Subject: Director General's Environmental Assessment Requirements for MP 08_0113 Proposed Housing for Seniors or People with a Disability, 216-222 Main Road and 21 Rowland Terrace, Toukley.

Following a review of the Preliminary Assessment and accompanying architectural plans, prepared by Ancher, Mortlock & Woolley, dated 19 November 2008, the Department reiterates its continued and ongoing concern with the excessive height, bulk and scale of the development.

MAIN ROAD ELEVATION

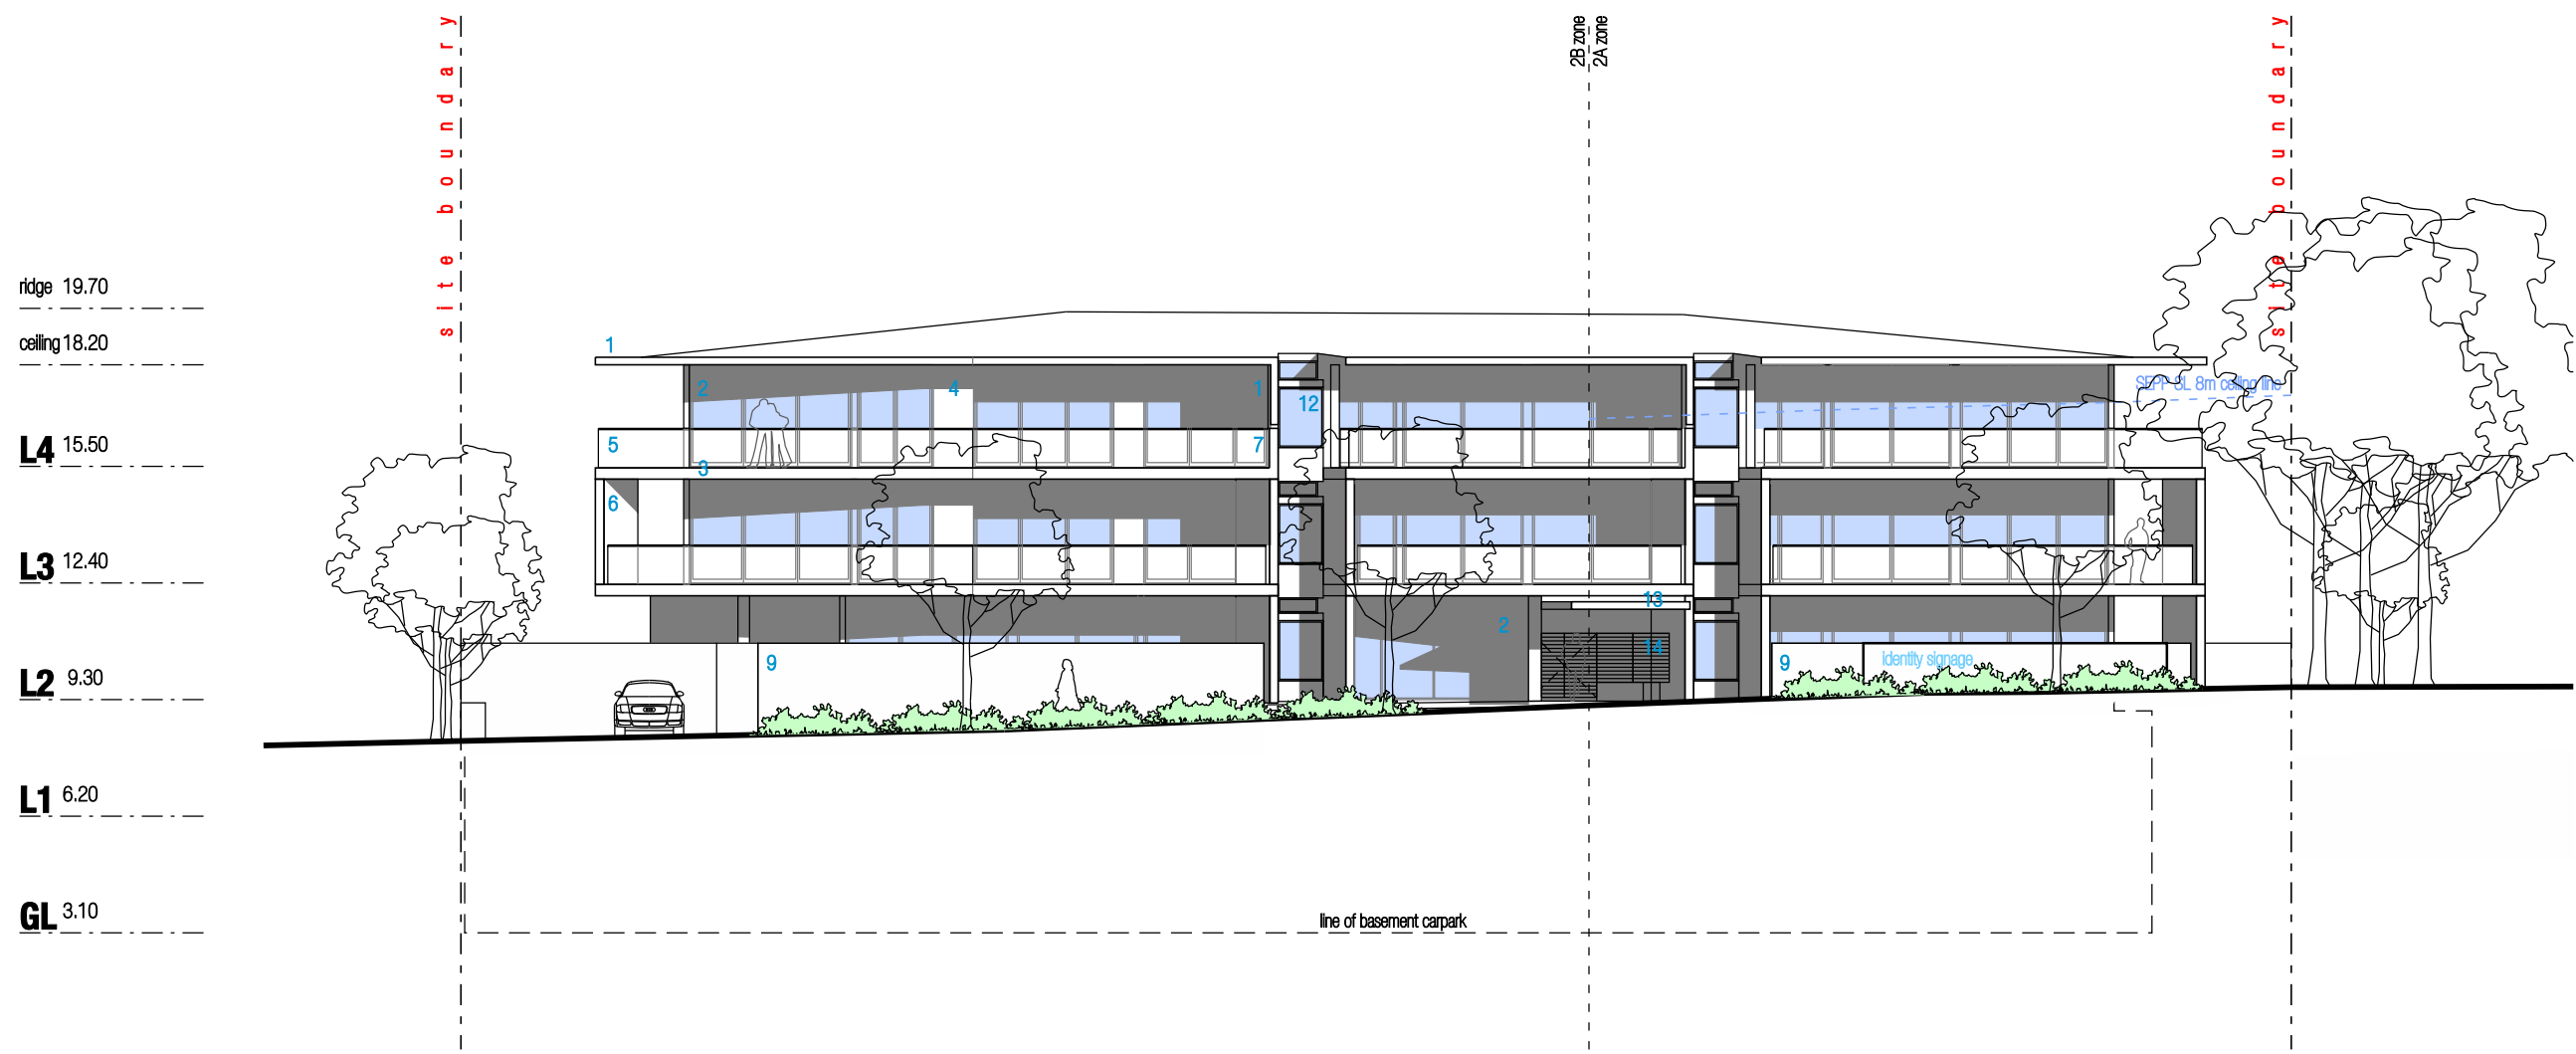
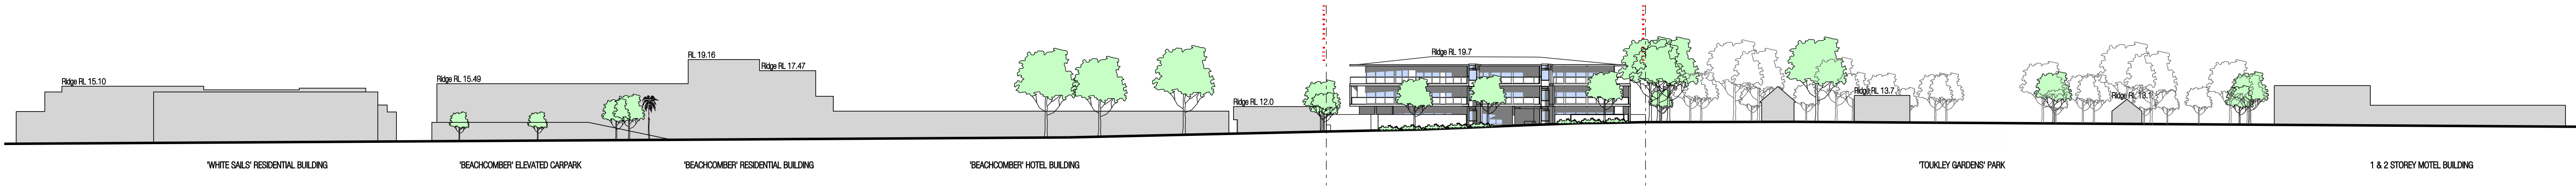
You are strongly encouraged to reconsider your proposal in light of these concerns and provide a proposal that is a maximum of 4 residential storeys to the foreshore and 3 residential storeys to the Main Road grading to a low scale 2 residential storeys at Rowland Terrace.

ELEVATION FROM LAKE

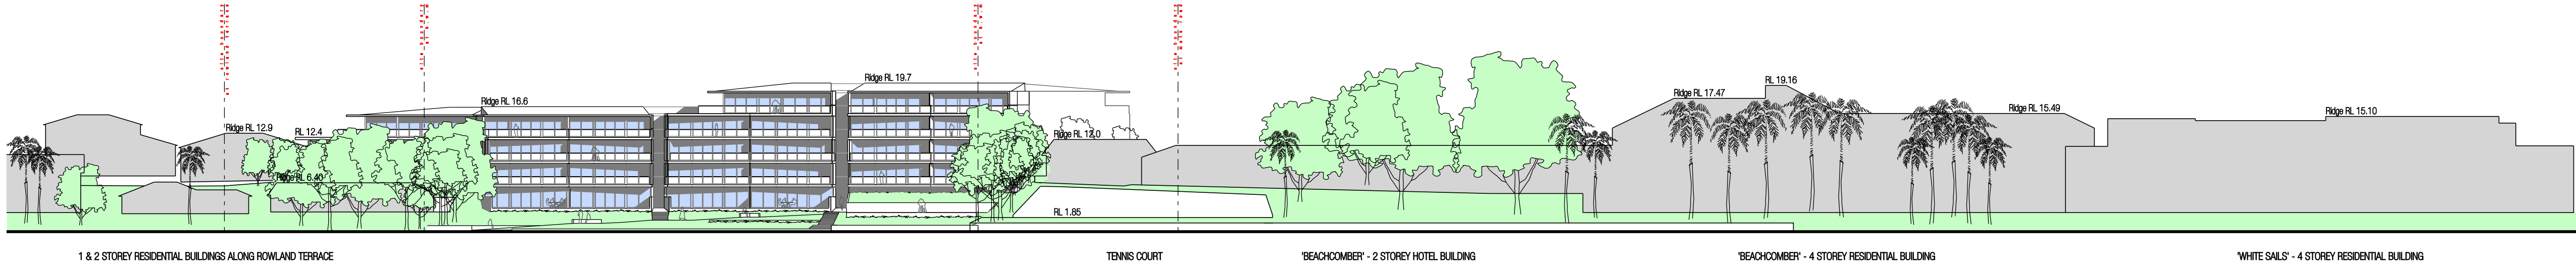
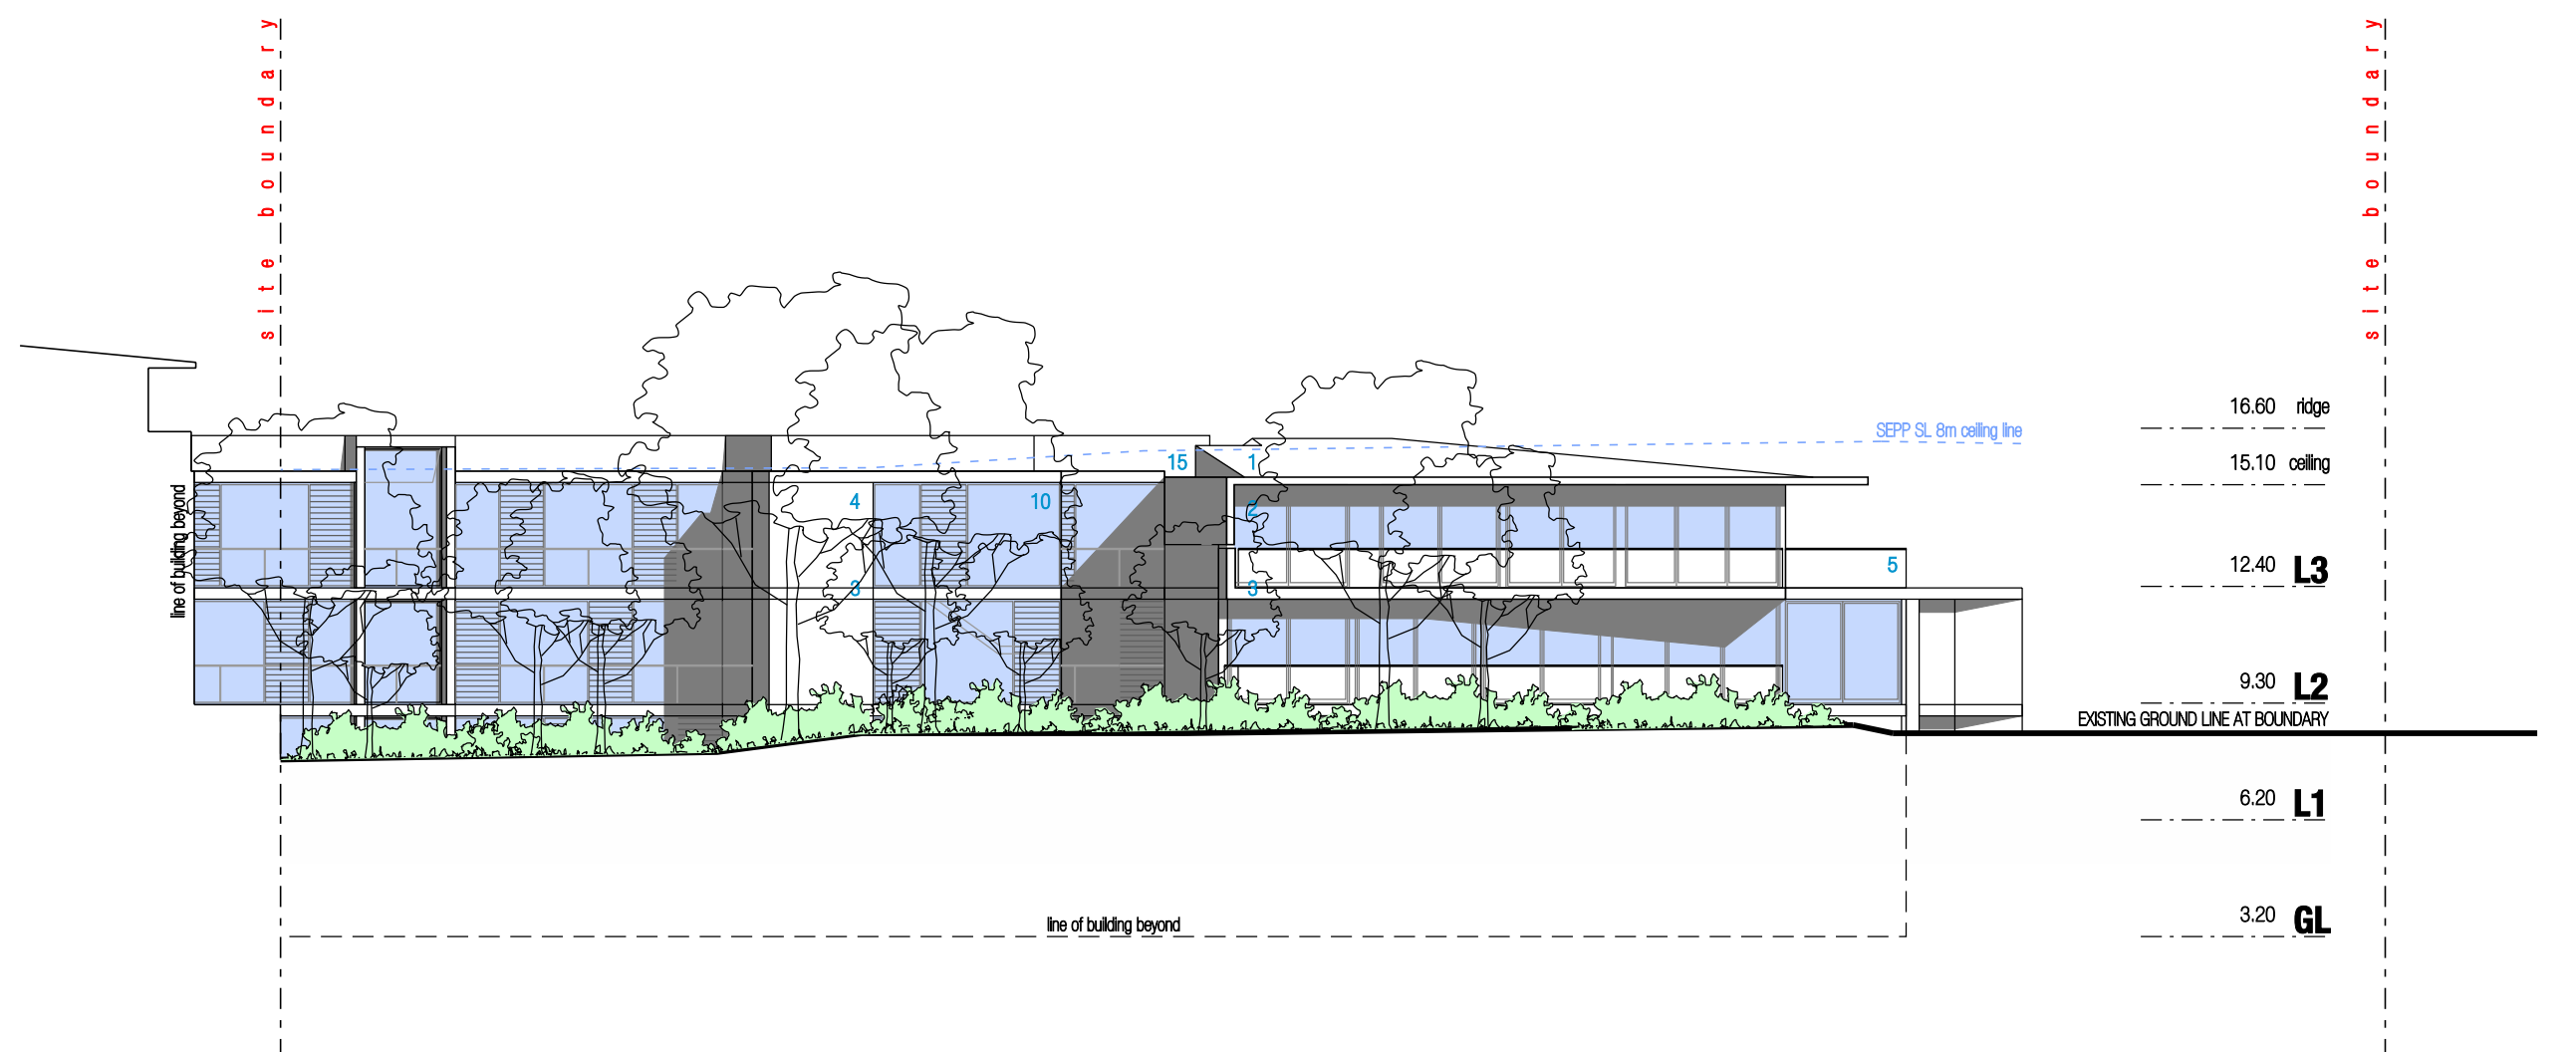
Furthermore, the separation between buildings should be increased to avoid the continuous wall effect when viewed from the water.
